From: Natasha Garcia <natashadgarcia@gmail.com>  
Sent: Monday, October 3, 2022 9:53 PM  
To: Molly McGuire  
Subject: File 2207-019 Comments

BASEMENT PLAN

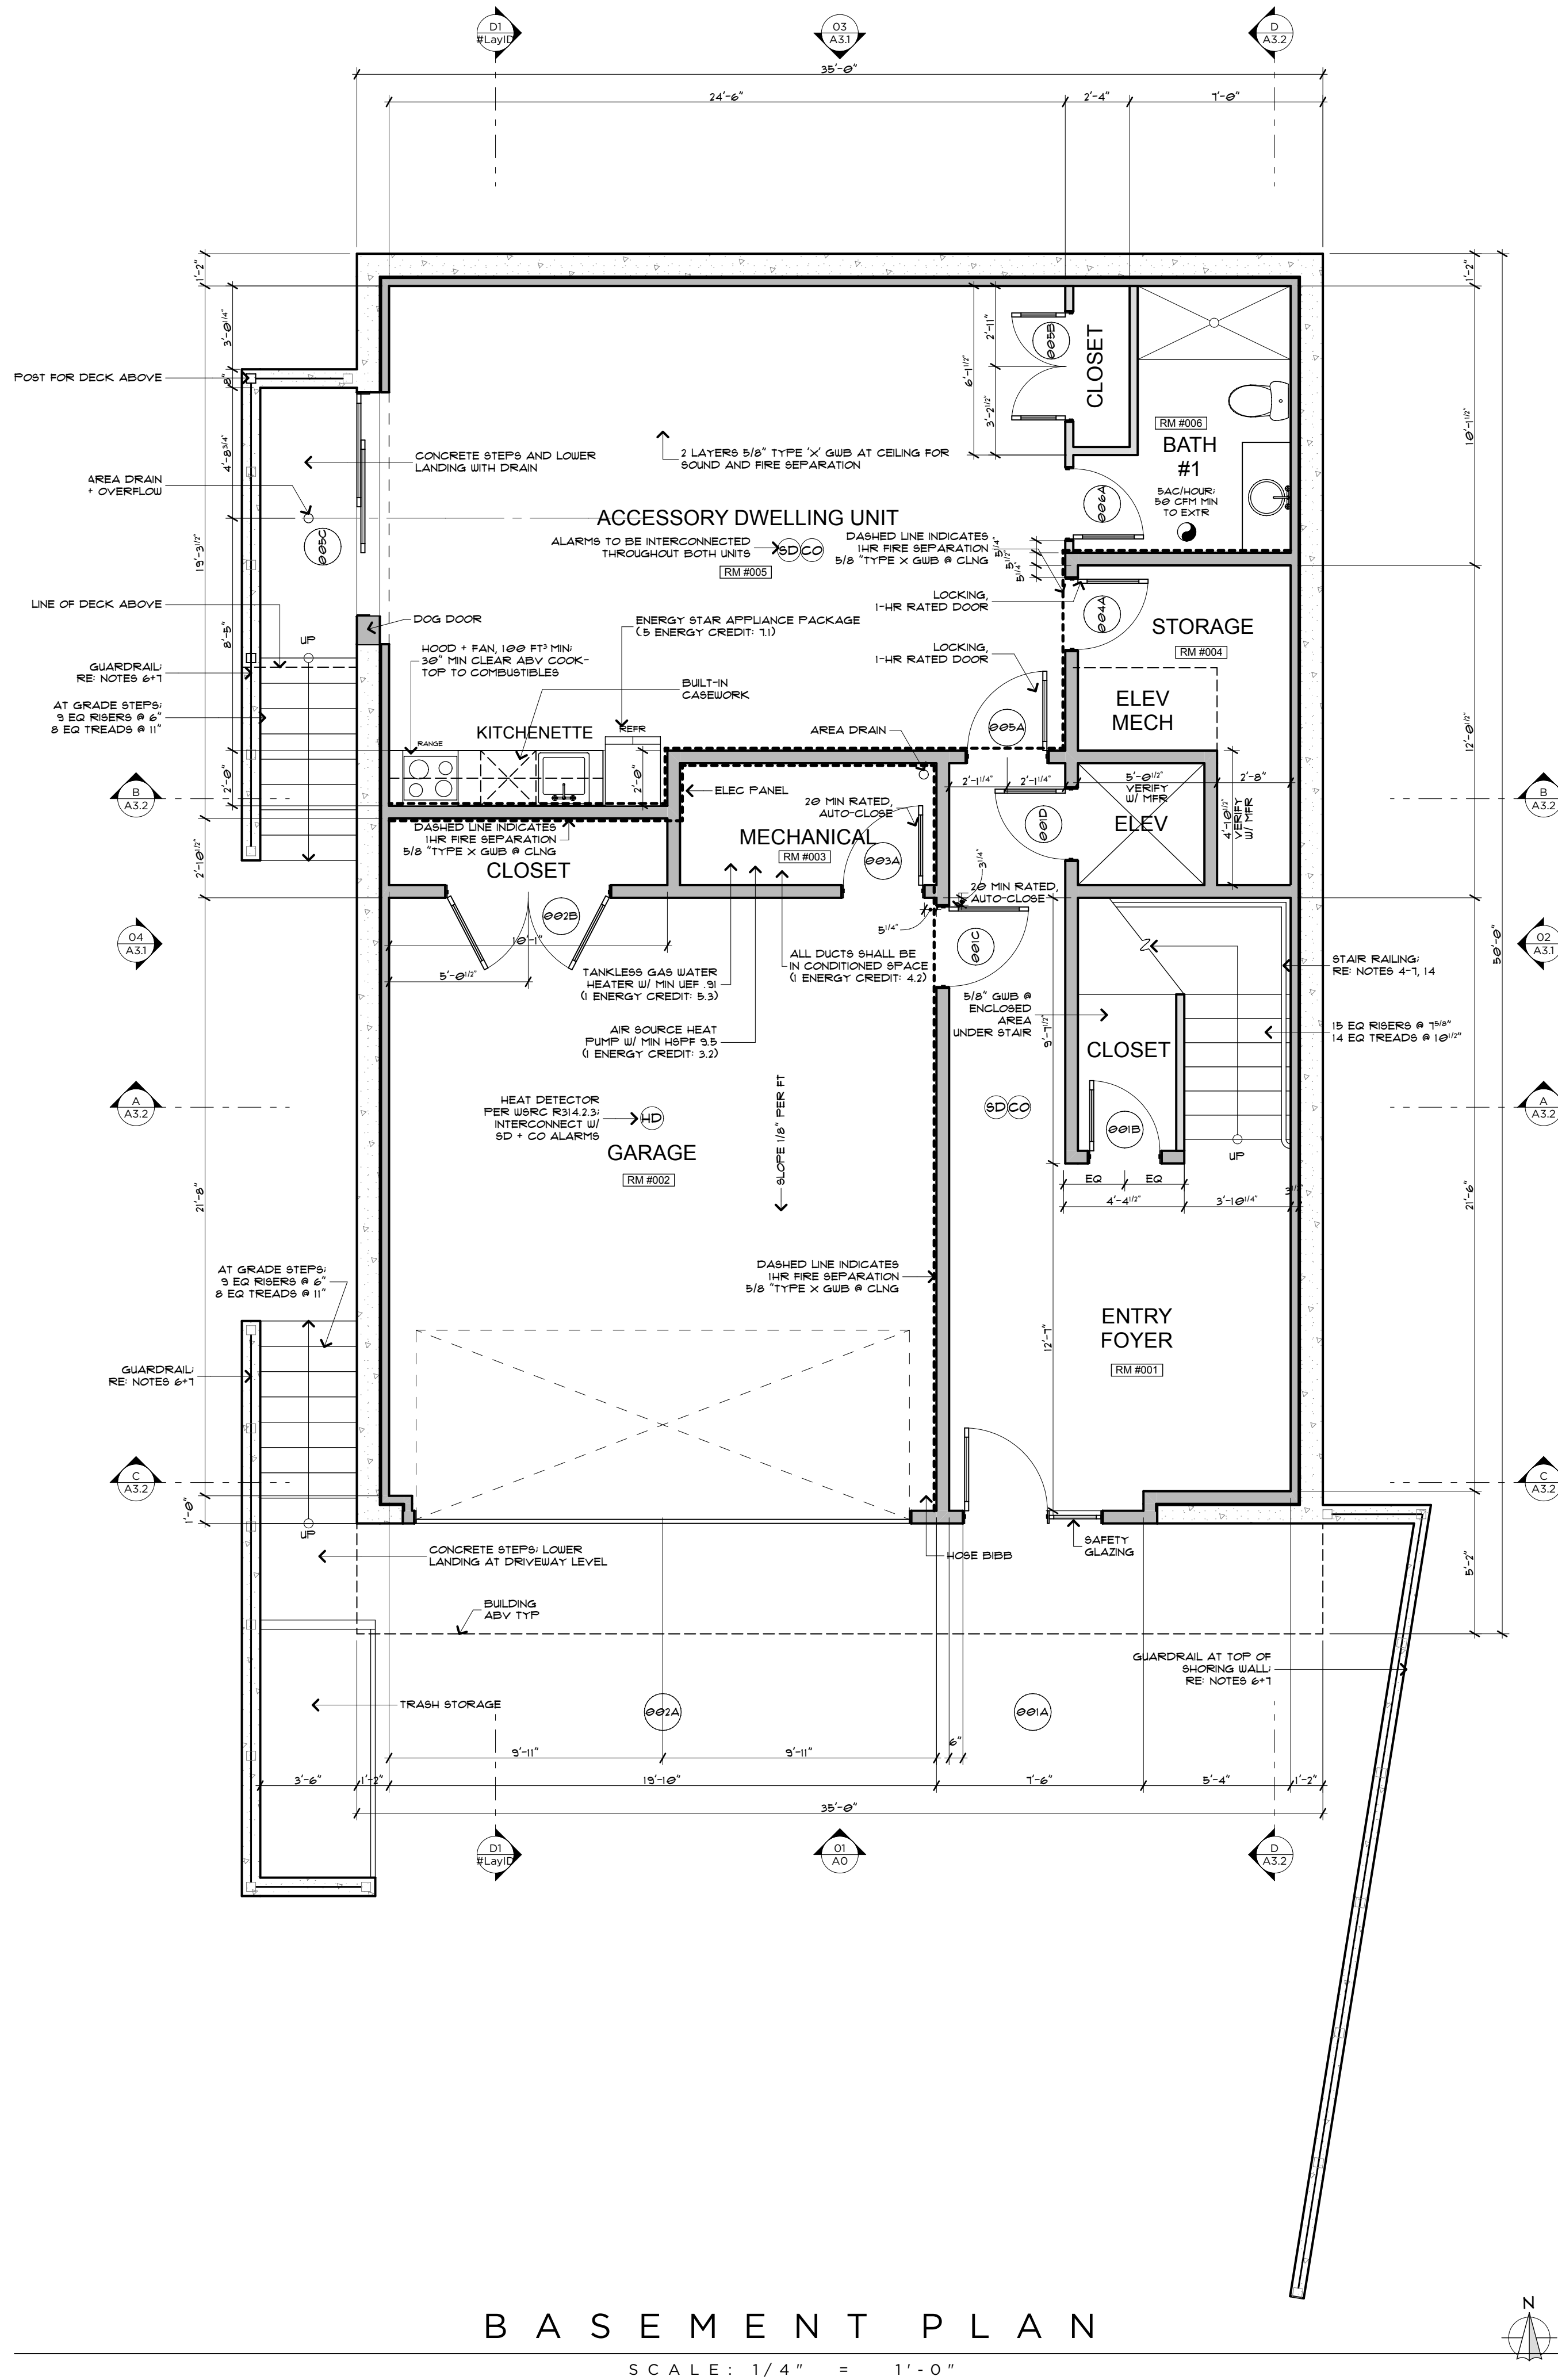
We received a notification in the mail of the request to build a new home at 9650 SE Maker St. My understanding is that the new building square footage inaccurately excludes the basement from the total square footage of the lot. Our house as well as our neighbors (and the lot in question) are considered style code 16 - 1 story with basement...but the square footage is basically at max of our lots since we include the first level (basement/no windows in back) of our homes. This new home would violate the gross floor area calculations allowed in our zone. In addition, this new home is being built on elevated land - there is a retaining wall directly in front of where this home is being proposed to be built.

I'd like to have my concerns noted in the comments for this structure as I feel that the size of the house is planned to be far larger than allowed in our zone.
